### **DCCDLC Short Plat (SP-06-64)**

### RE: DCCDLC Short Plat (SP-06-64)

The Kittitas County Community Development Services Department has determined that the DCCDLC Short Plat is a complete application and hereby grants **conditional** preliminary approval subject to the following conditions:

DCCDLC SHORT PLAT

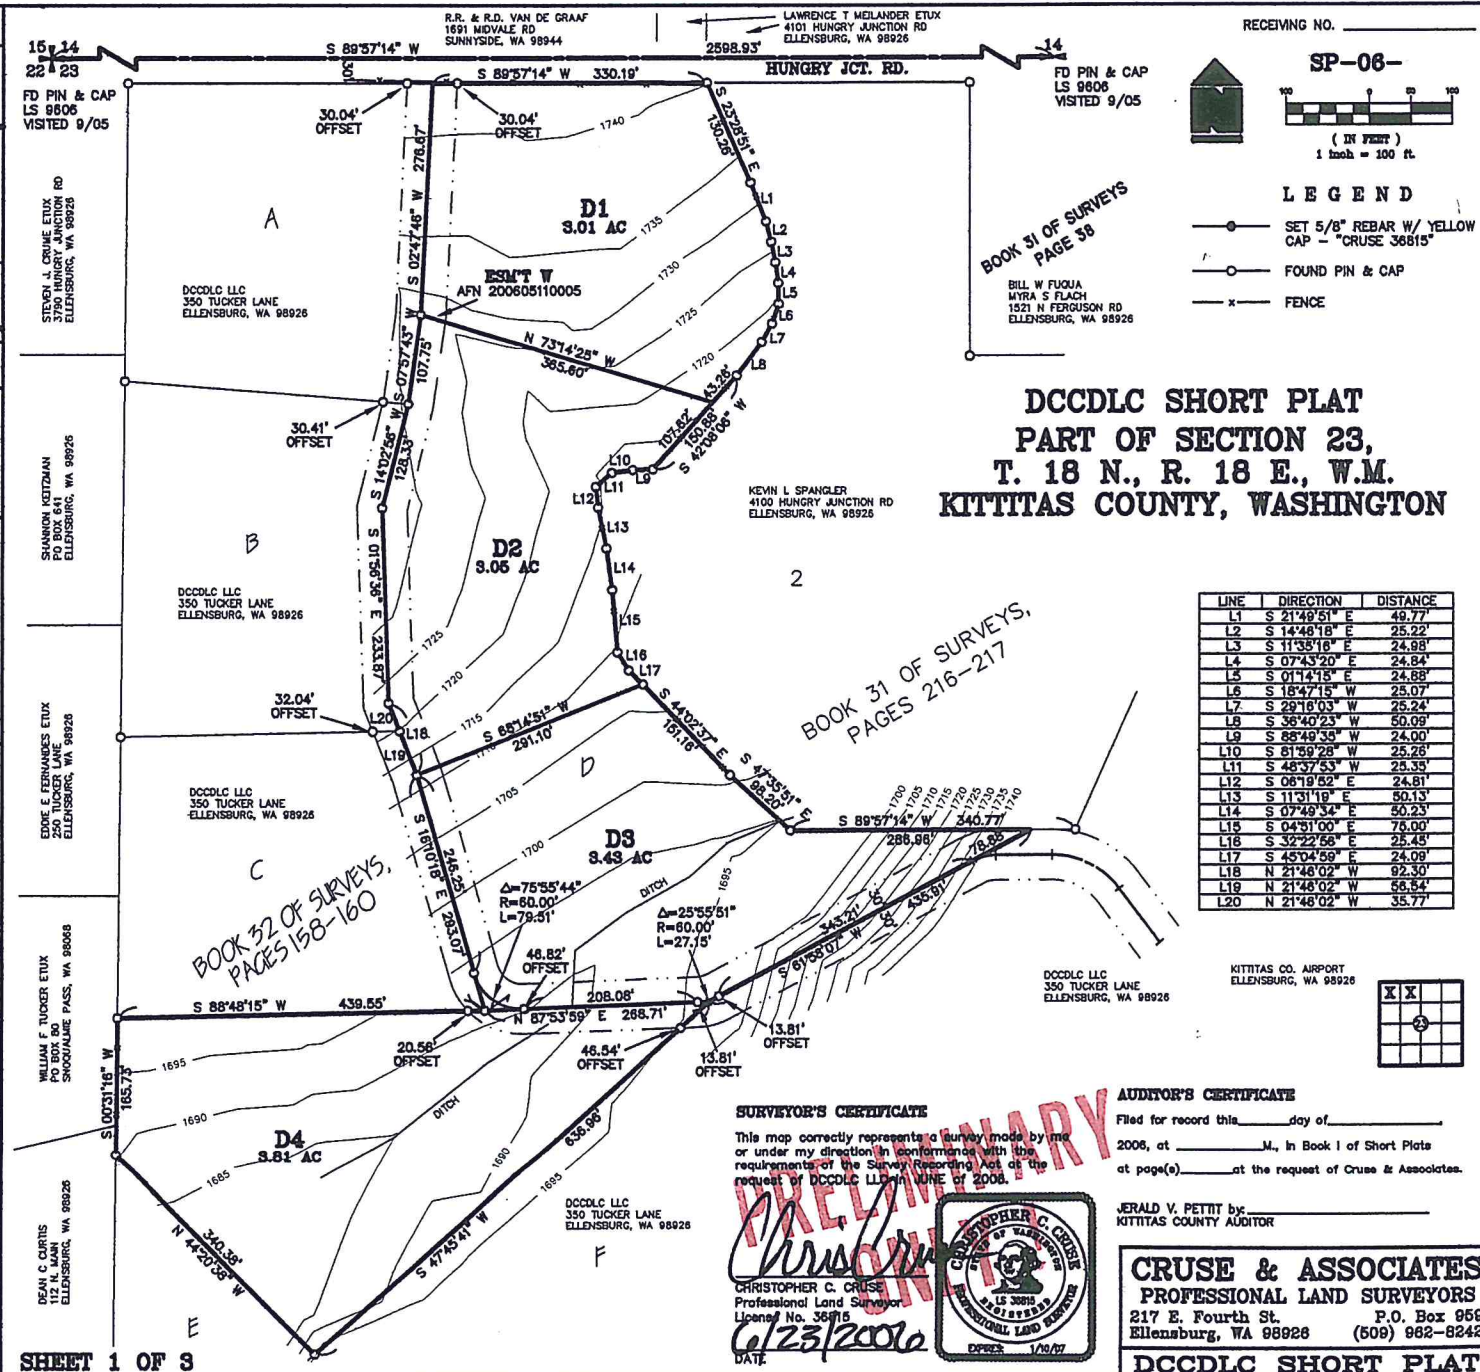
1. Both sheets shall reflect the short plat number SP-06-64.
2. The continuation of the ditch exiting lot D4 must be shown on the final mylar.
3. There is a PEMC wetland on lots D3 & D4. This must be shown on the final mylar. Please see attached map for further information regarding the location of said wetland.
4. A notice from KRD approving an irrigation plan must be received in the CDS office prior to final plat approval.
5. Please contact Randy Carbary at 962-7019, Kittitas County Public Works, regarding all road standards and access questions.
6. Attached you will find comments from Kittitas County Environmental Health. **Please see those documents for required plat notes and information on issues needing completion before final approval of this short plat.**

1. The map on the back page does not clearly indicate that the fire department access road will be 20' wide and capable of support 75,000 lbs with an all-weather surface. It is also not clear that the turnarounds comply with Appendix D of the 2003 International Fire Code.
2. The addresses need to be clearly visible from both directions at the county road for all properties.
3. If the property is gated, the fire department will require an access padlock be provided by the owner/developer. Padlocks run approximately 80.00 and an access box runs 150.00.
